Boston Alternative Energy Facility

Natural England's Advice on Ornithology Documents Submitted at Deadline 3 and 4

Planning Inspectorate Reference: EN010095

25th January 2022

**Figure 2-1 Noise contours for construction without piling in daytime**

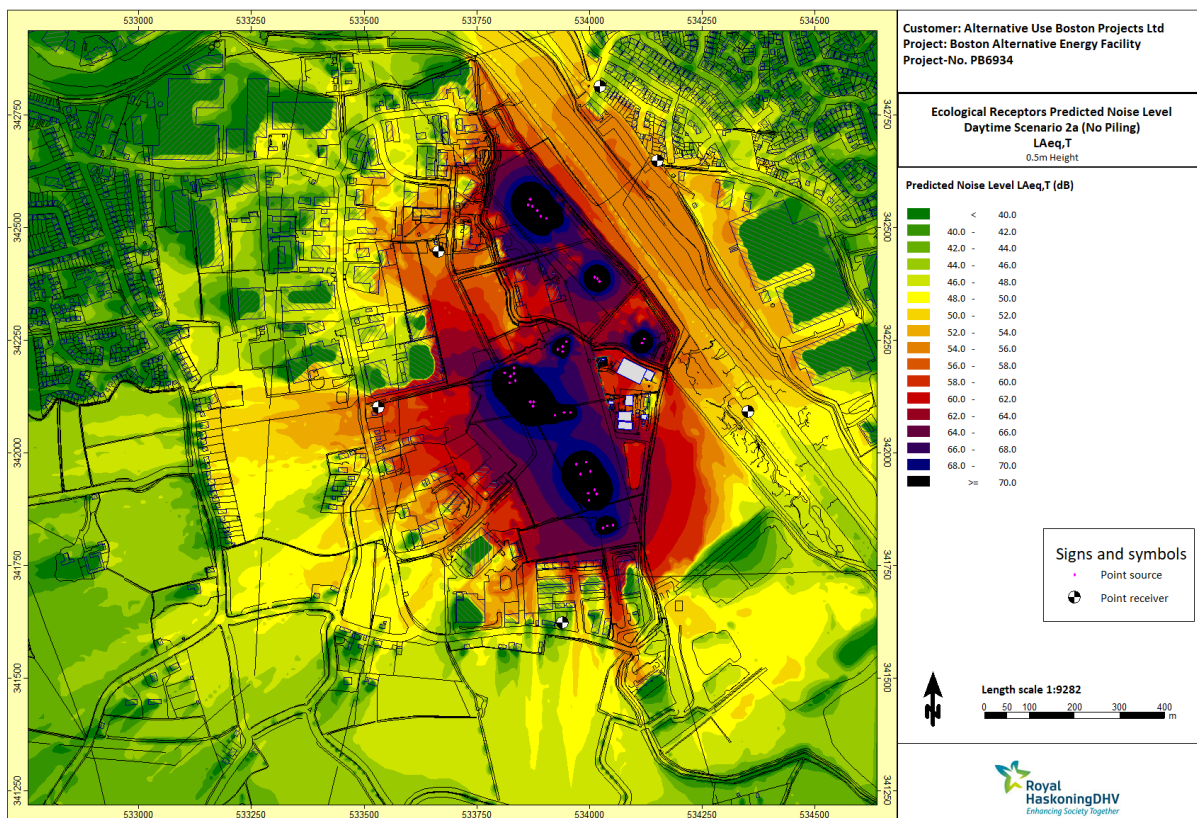
9.	2.1.1	<i>'Construction no piling in daytime: 'the predicted receptor noise level is 49.7dB' (at mitigation roost); 'noise levels of 50-56dB over most of the adjacent length of The Haven' (foraging areas)'</i>	NE accepts that during the daytime no piling construction noise disturbance is unlikely to be detrimental at the roost site and over most foraging areas.

**Figure 2-2 Noise Contours for Construction with piling in daytime noise environment of local area**

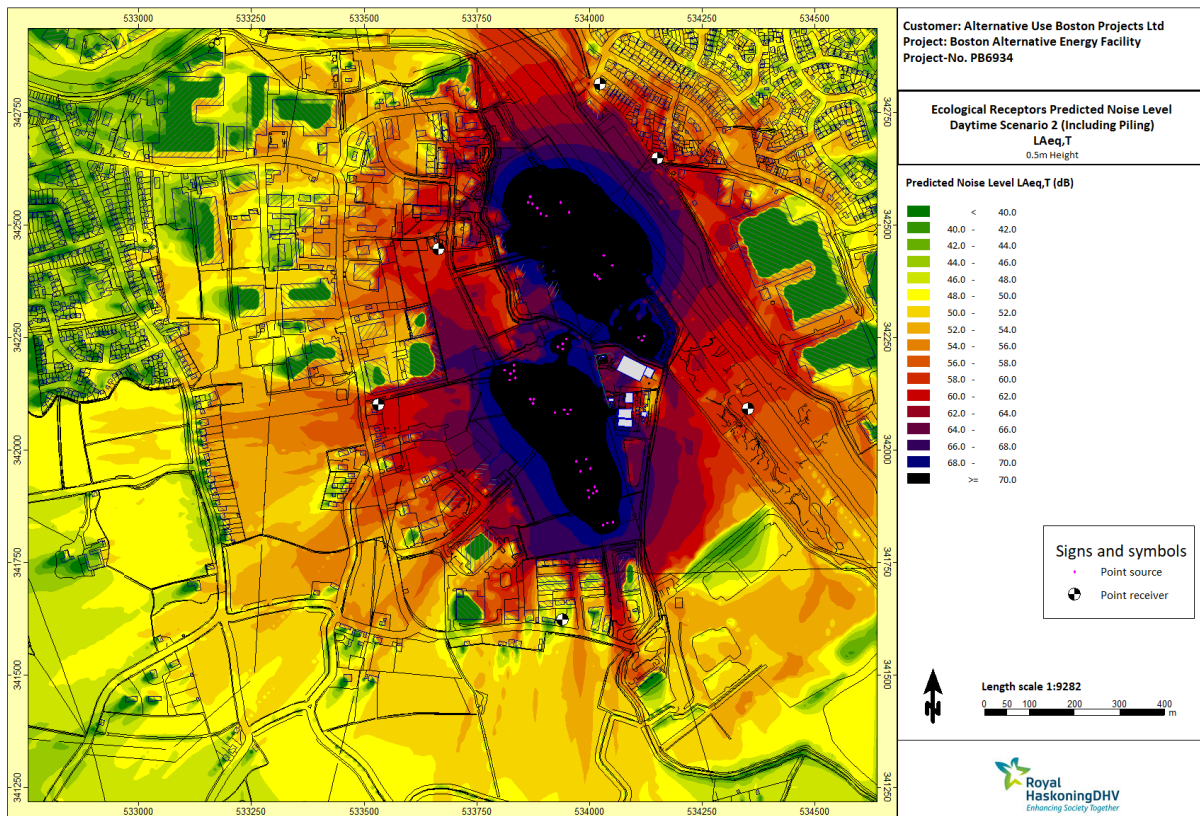
10.	2.1.2	<i>'Construction with piling in daytime: 'At the highlighted redshank roost site in this location (the point receiver within Area B (as shown on Figure 11) in Figure 21 below), the predicted</i>	NE considers that piling activity is likely to be disturbing to both birds using the mitigation roost area and foraging. NE considers that managing this activity to the months of June-September as identified at 1.1.1

receptor noise level is 58.5dB' (at mitigation roost); '). Along an approximately 400m section of The Haven in bird survey area A (in line with the constructions on Principal Application Site), noise levels are modelled to range from 66-68dB on the opposite bank of The Haven to 74-76dB on the near side of The Haven (Figure 2-2, Figure 2-3)' (foraging areas)	will reduce risk to key species as will the adaptive management provisions identified at 1.1.1. NE considers it important that these safeguards are in place while this activity is ongoing. Therefore, an outline mitigation management plan is required prior to consent with a condition that the final plan is agreed in consultation with NE prior to the works commencing. This is be secured in the DCO/dML

11.	2.1.2	'Using the 54-56dB contour as a guide, there is an approximate 450 m radius around piling-period construction sources within which redshank would experience 'caution' levels of at-bird noise level or higher'	NE notes that the 450m zone of risk is greater than the 250m identified in 1.1.1 and advises that the 450m zone is the correct one for the application of the adaptive management.

Figure 2-4 Noise contours for construction without piling in night-time

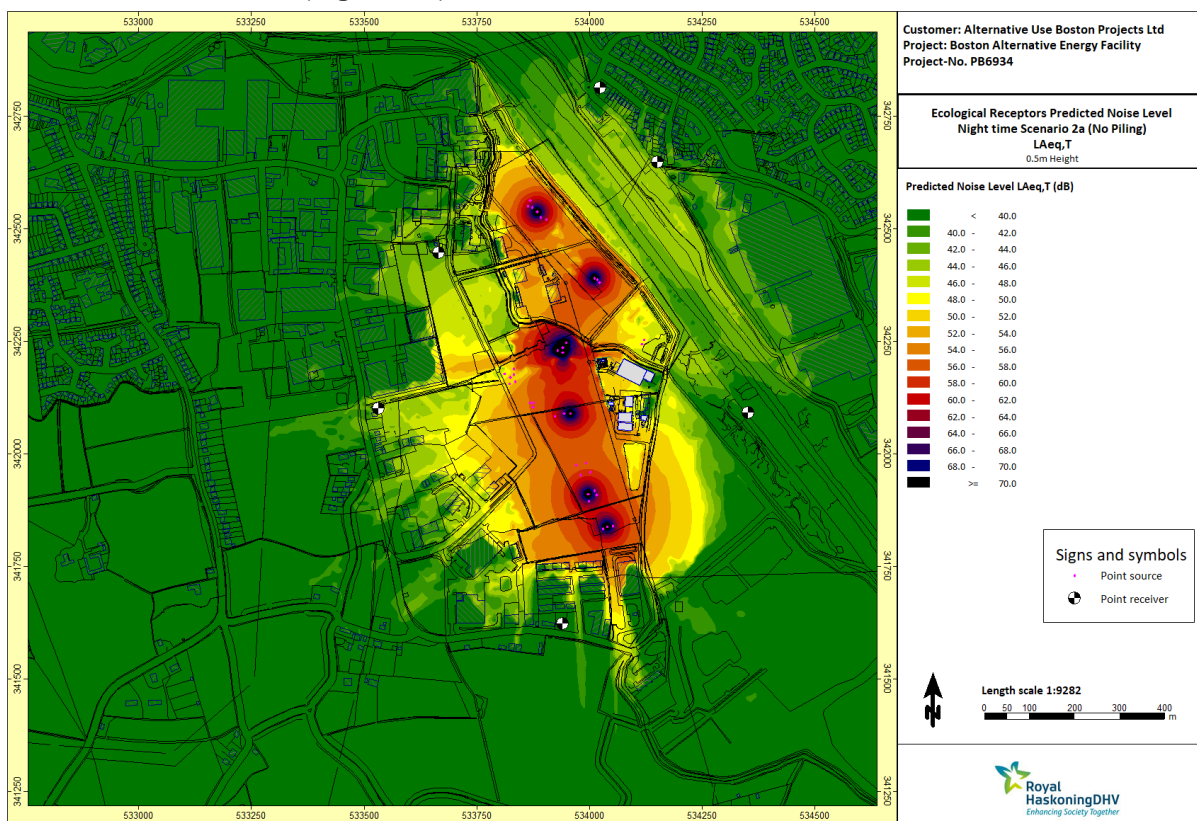
12.	2.1.3	'Construction without piling at night: 'the predicted receptor noise level is 37.6dB.' (at mitigation roost); with noise levels reaching 44-48dB on The Haven (foraging areas)'	NE accepts that at night time no piling construction noise disturbance is unlikely to be detrimental at the roost site and foraging areas.

Figure 2-5 Noise contours for operating the project site in daytime

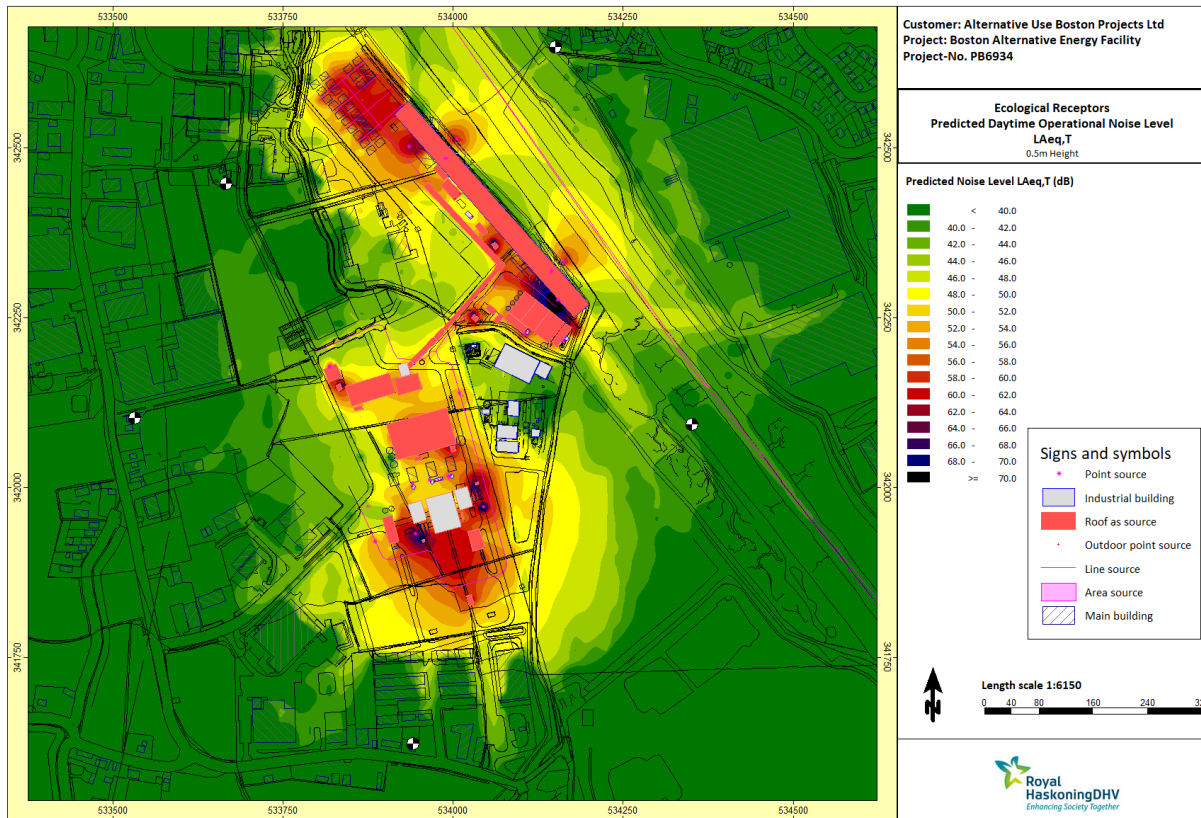
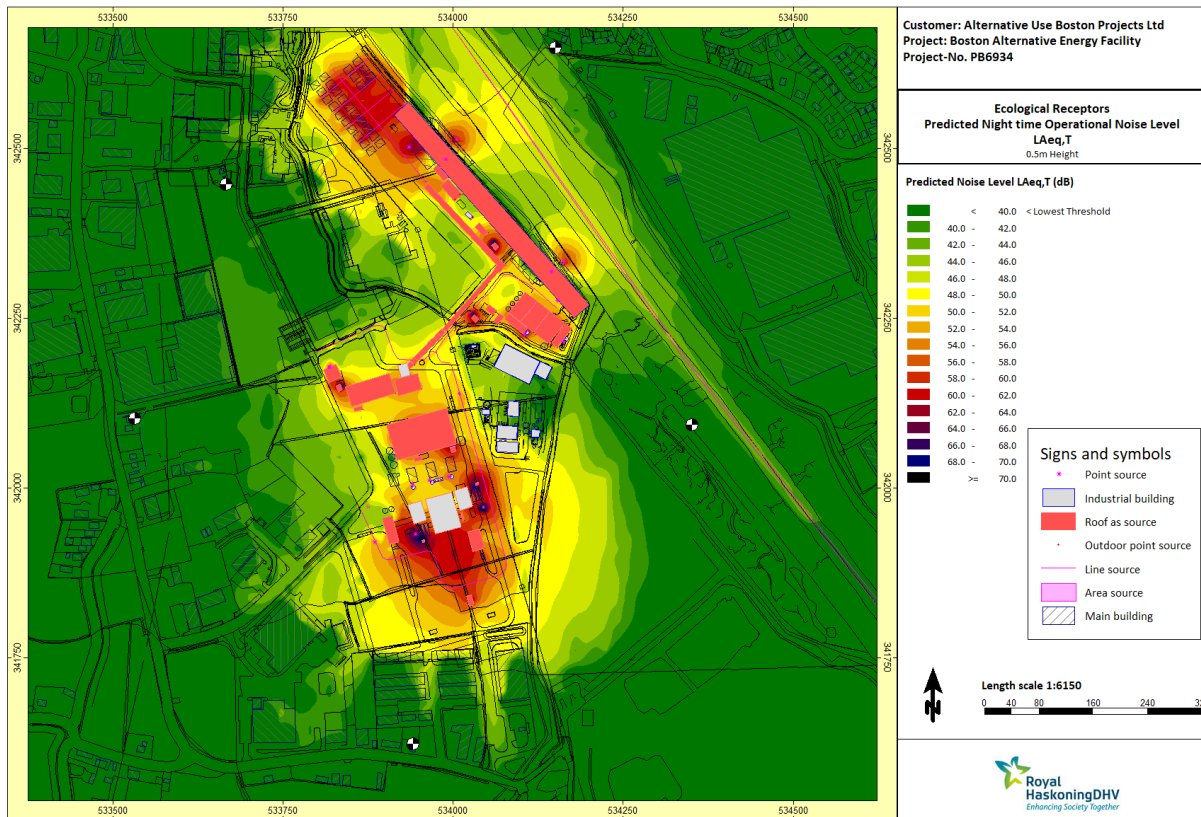
13.	2.2.1	'Operational phase: 'the predicted receptor noise level is 38.8dB during the day and 37.6dB at night' (mitigation roost area); 'reaching 54-56dB in two small areas (a radius of around 30 m and 40 m around the two respective point' (foraging areas)'	NE accepts that operation noise disturbance is unlikely to be detrimental at the roost site. Some disturbance may occur affecting foraging areas and best practise would see these point source areas being managed to reduce noise levels e.g., through adoption of noise screens around the point sources. It should be noted that these noise levels risk permanent loss unlike the similar noise levels identified at 1.1.2 (construction no piling) as those are temporary. Therefore, we advise that further commitments to mitigation measures as set out above are required by the Applicant to ensure that the impacts are further minimised. Once agreed this should be secured in the DCO/dML or as part of a named plan.
